Submission re design changes to Redfern Station

TfNSW “Preferred” Solution

FIGURE 5-2: KEY FEATURES OF THE PROJECT

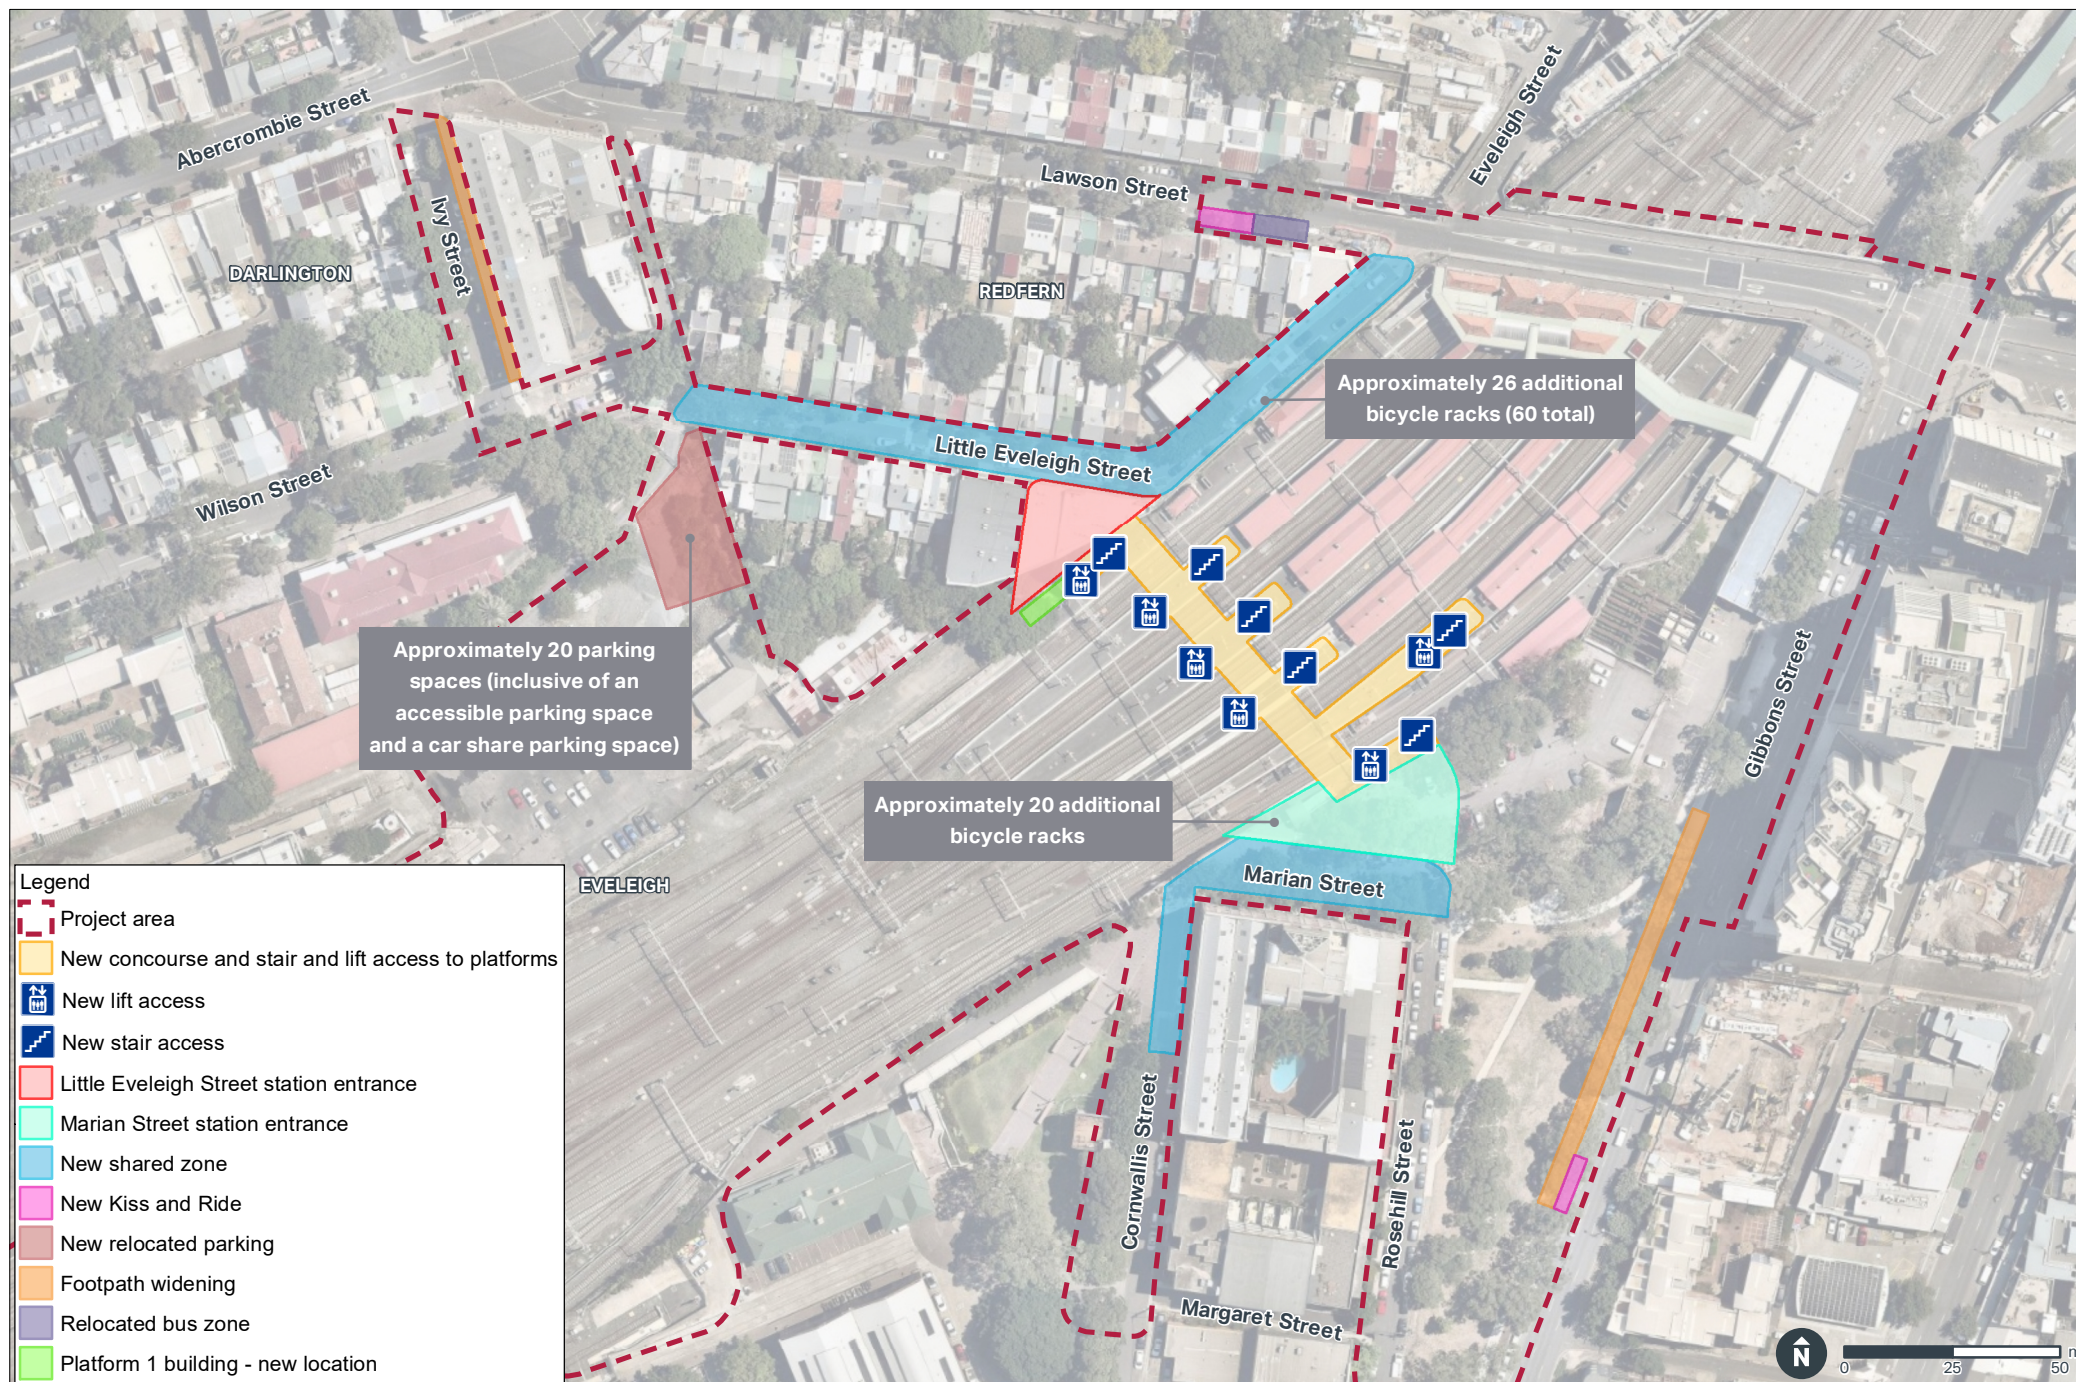
The safe and practical solution is to design the entrance to the lift concourse south of the Cornwallis/Marian Street corner so the 20,000 people exit directly into the South Eveleigh precinct. Both alternative community group designs (“H” design and Option 5) depicted in the TfNSW’s Scoping Report incorporating this solution were presented by the ReConnect Redfern action group but TfNSW has deemed this as not preferred on the basis of unsubstantiated objections.

There is no presented solution to counter the inevitable privacy issues emanating from the proposed new station entrance impacting the Watertower apartments, as it is apparent that the height of the public concourse is (while not depicted) is obviously high above ground level. (i.e. will commuters see into The Watertower apartment windows?). Again the EIS is silent on this matter.

The impact of the station entrance/bridge structure on the natural light and shadow lines for north facing Watertower apartments has not been made available to the public and is not addressed at all in the EIS.

16 street car parking spaces around The Watertower will be permanently removed. Other than finding parking elsewhere, there is no suggestion of any replacement parking spaces.
